Mears Ashby Issues and requests. Mar 2026

As this project is about to enter the Examiners review stage, we would like to submit further recommendations, without prejudice, in the event that the examiners approve the DCO. We believe these recommendations would make it more acceptable to the local community.

Drawing file: published-documents / EN010170-000468-GH6.4.13.17_ES Figure 13.17_Access Locations for Sites and Cable Route Corridor_South Area Sheet 3.pdf

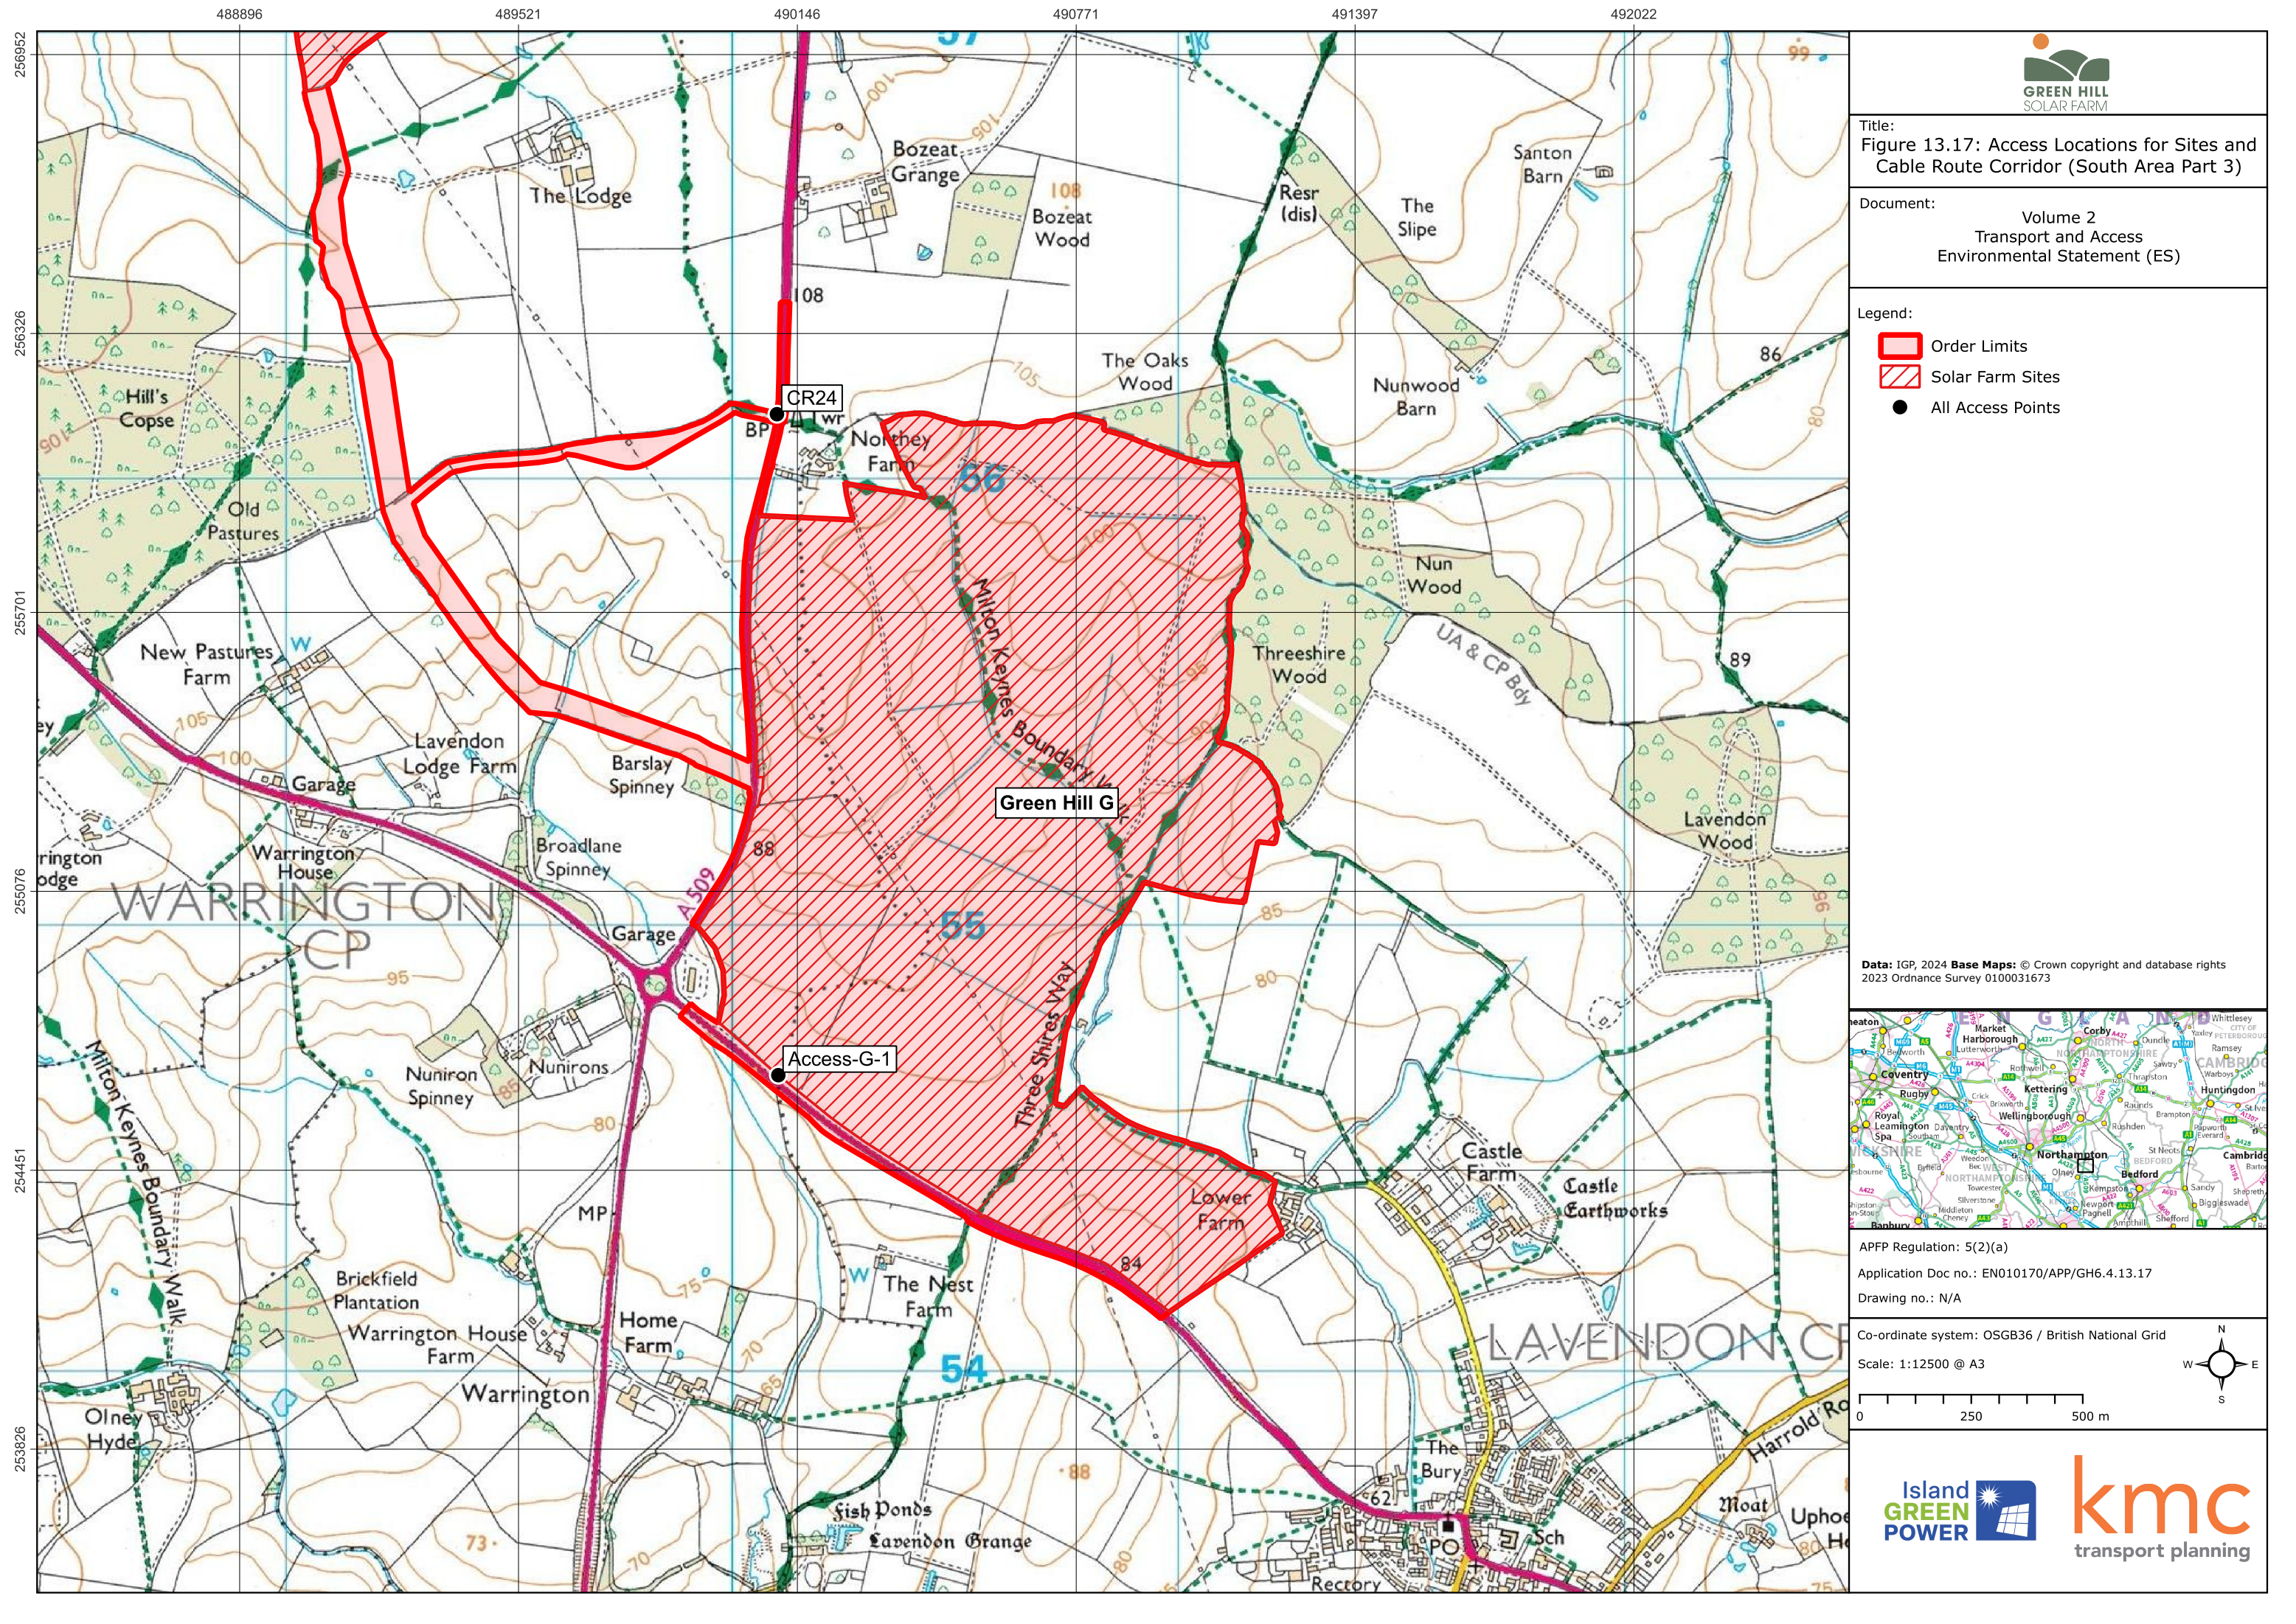
Highfield Road. Please can you review the 5 access points (which includes the cross-over for the cable route) on this road into sites D & E It is a short narrow country road, only 7m wide. The verges and road edges will not survive the number of HGV's you propose to service these areas. This is also a very busy commuter route and 4 sets of traffic lights will cause absolute chaos for commuters and school traffic.
